Application for Planning Permission for Works or Extension to a Dwelling

Development: Side facing first floor extension. (This application may affect the character and appearance of the Craigweil House, Aldwick Conservation Area).

Location: Bayswater 50 Kingsway Aldwick PO21 4DN

EXISTING ELEVATIONS

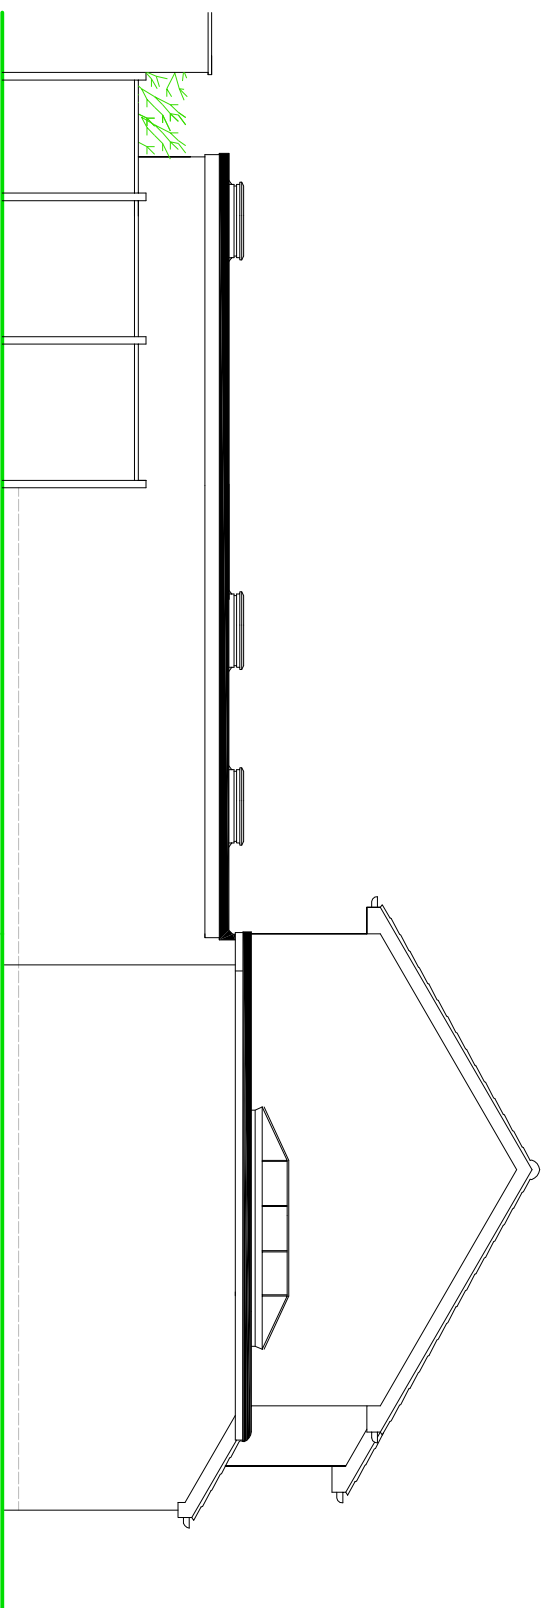
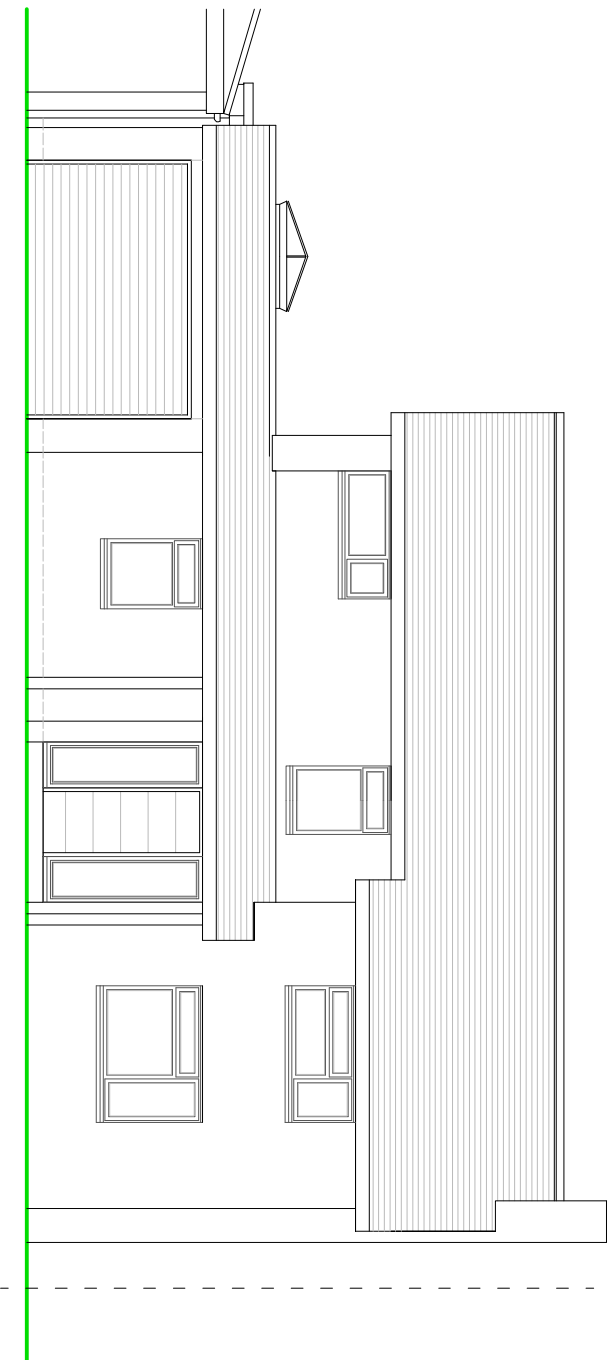
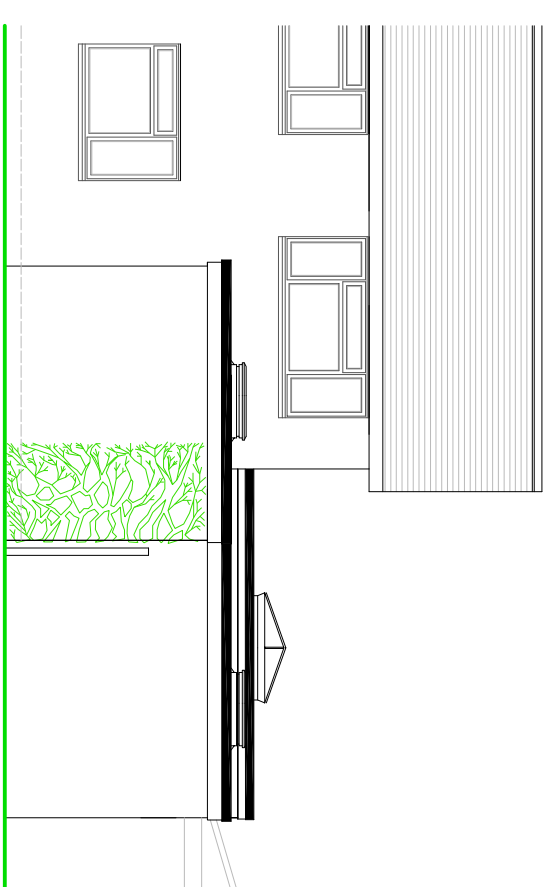
The windows are inconsistent between the existing front elevation and the existing first floor plan, please review and amend.
